6th April 2014

Re: Campus Improvement Program (CIP) State Significant Development (SSD 13_6123) Environmental Impact Statement.

01 ENGINEERING - SHEPHERD STREET ELEVATION PROPOSED

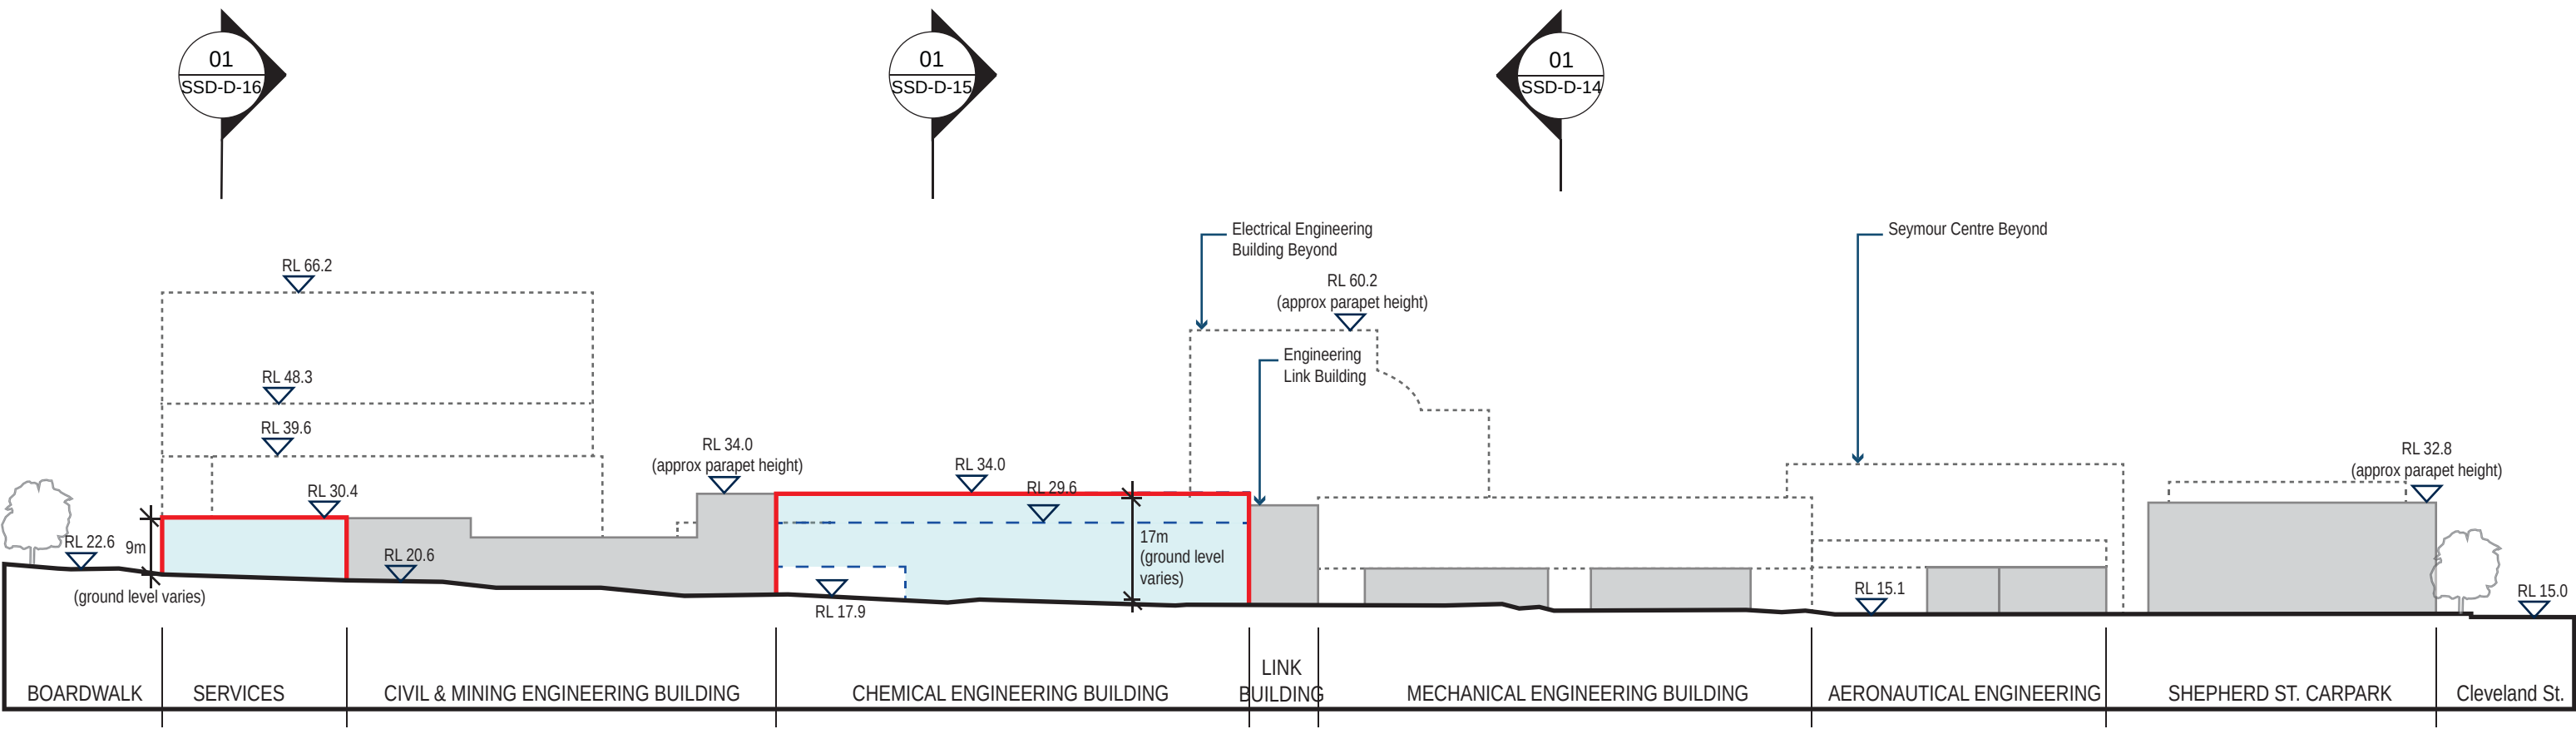
REDWatch is aware of the local concern about the proposed replacement of the existing trees along Shepherd Street with a new development. This grove of trees we have been advised by locals, was planted at the request of residents following an article about the problem in "Neighbourhood Witch" to soften the interface between the University and the surrounding community. REDWatch is concerned that this softening is to be replaced by a new building directly abutting the residential precinct. REDWatch submits that the CIP should look at softening the edge of the University along Shepherd Street and increasing permeability rather than placing a new building where the grove of trees currently stand.

REDWatch has concerns about University's servicing strategy in Shepherd Street as this service centre is across the road from residential buildings. The CIP proposal removes the capacity for trucks to enter the University at this point potentially placing the vehicles waiting to access the distribution centre in a narrow street in proximity to the main pedestrian entrance to the University.

01 DARLINGTON TERRACES - PROPOSED ENVELOPE PLAN

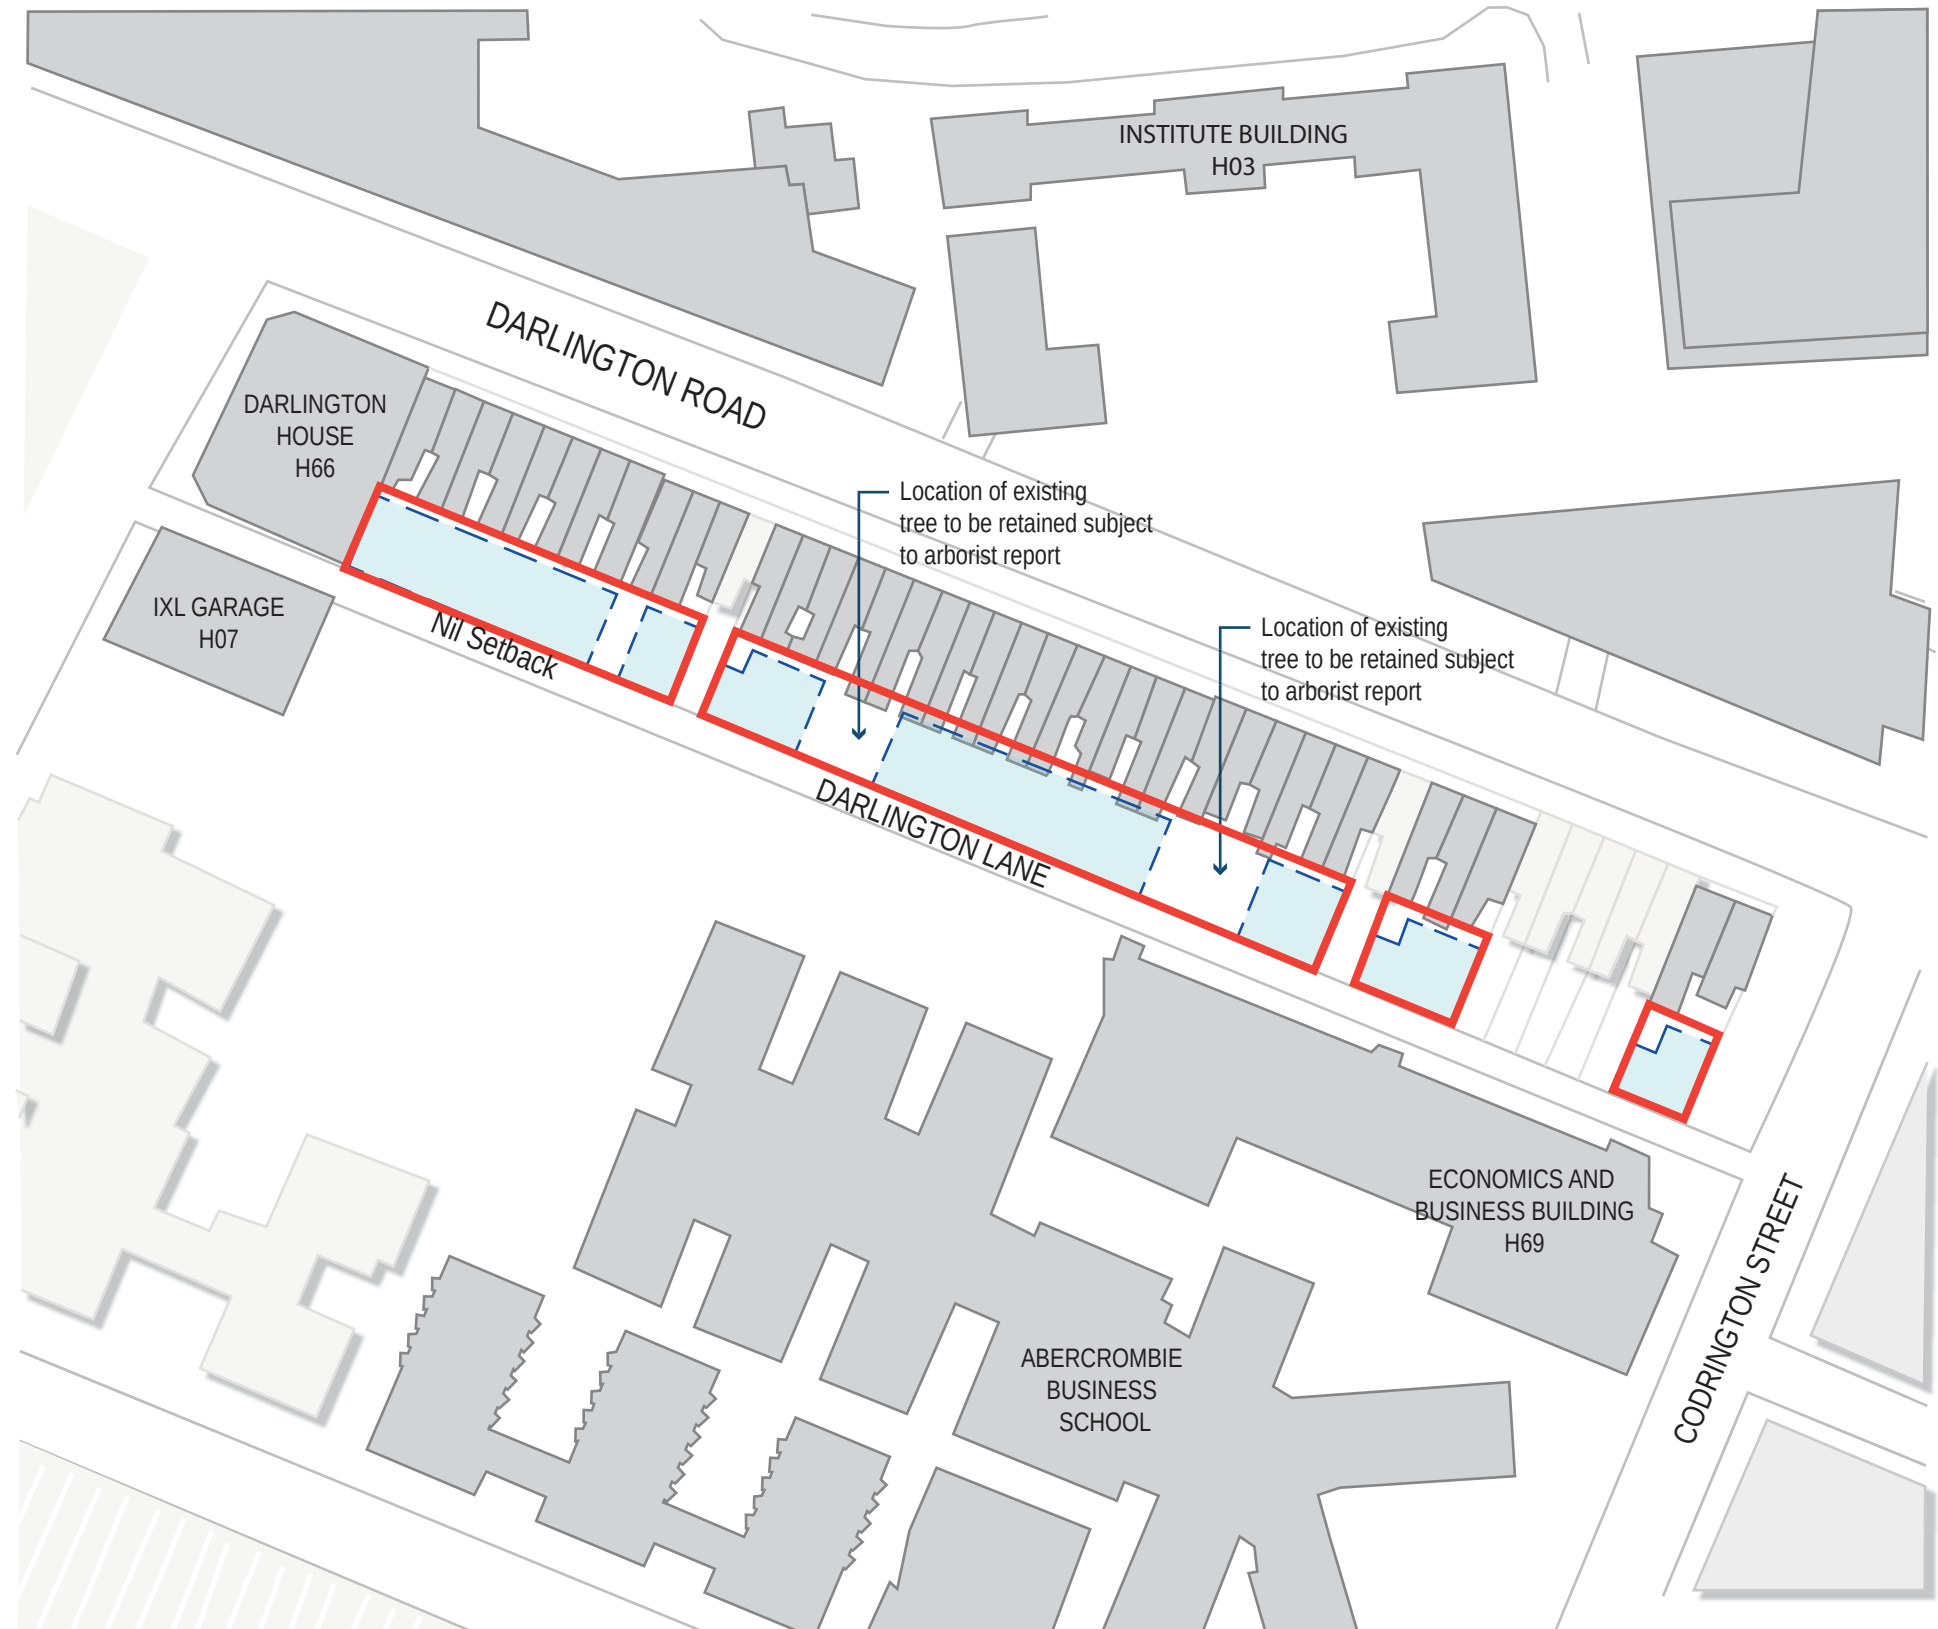
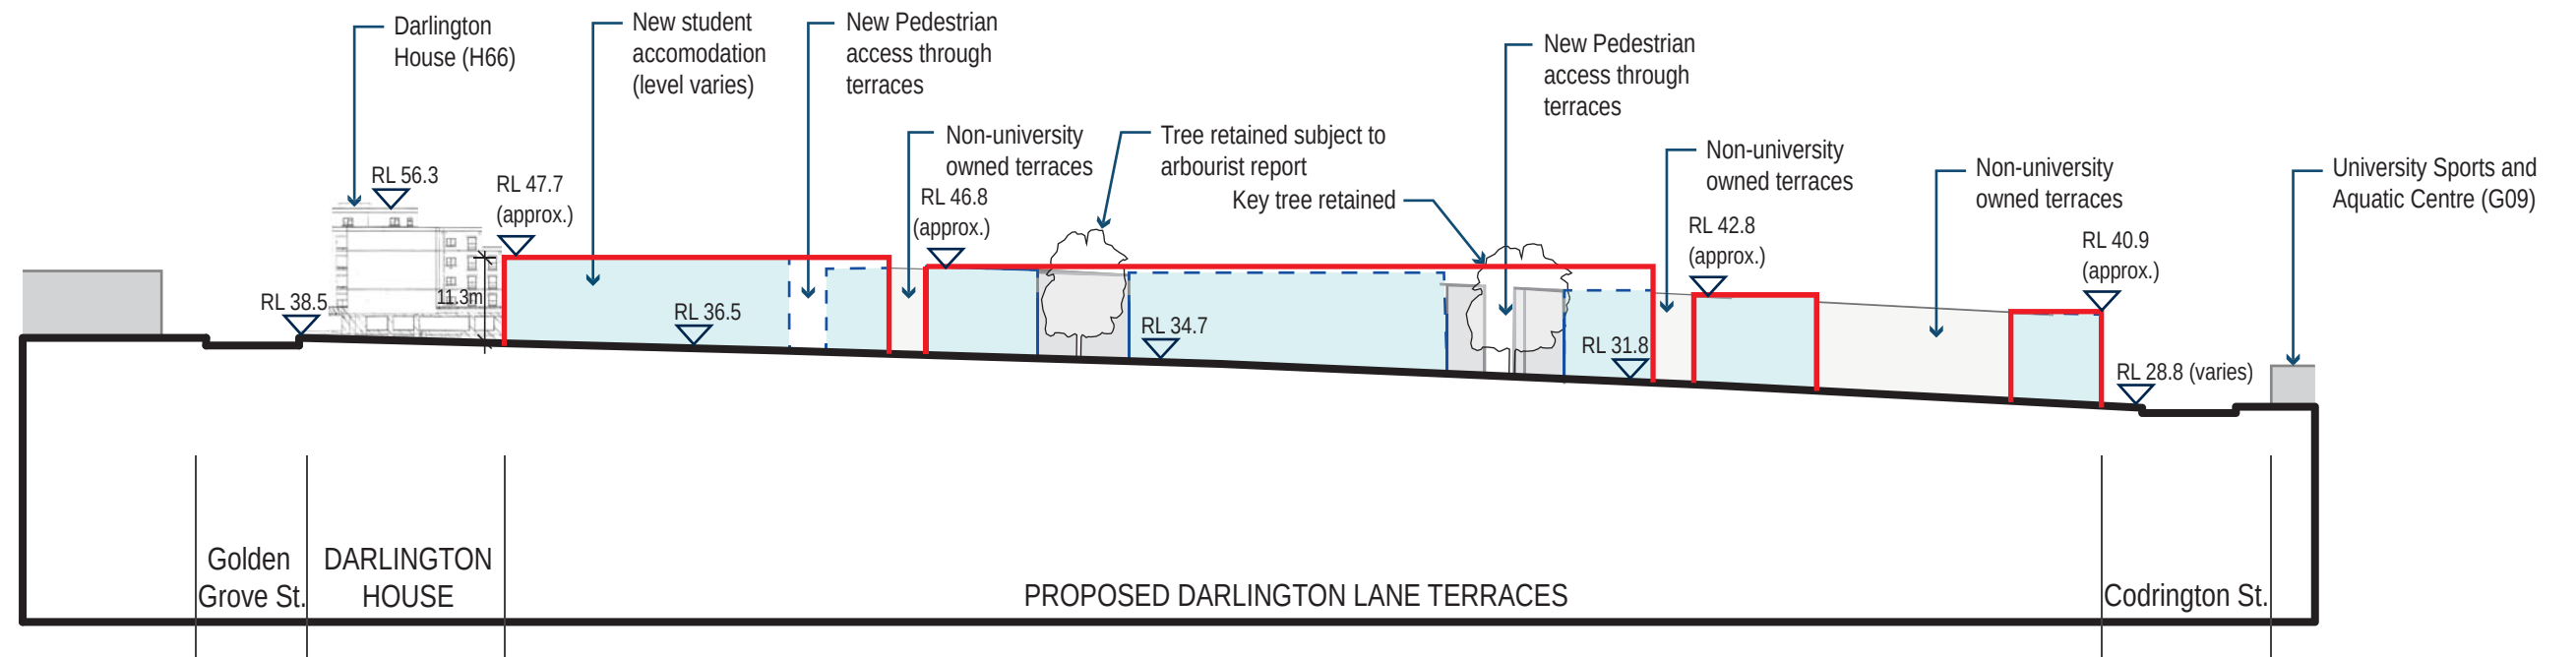
Over several decades the University has gobbled up much of the Darlington residential area. One of the few remaining features of the old residential area is the Darlington Street terraces. Currently the University does not own a number of these terraces and it is incumbent upon the University and P&I to ensure that development in proximity to these privately owned terraces do not deprive them of their amenity. The proposal for three-storey student housing to the boundary of private residences is opposed due to overshadowing and loss of residential amenity.

REDWatch also objects to three-storey student housing development in the backyards of the Darlington Street terraces as it degrades their heritage value especially as the plans show some encroachment on the rear of some terraces.
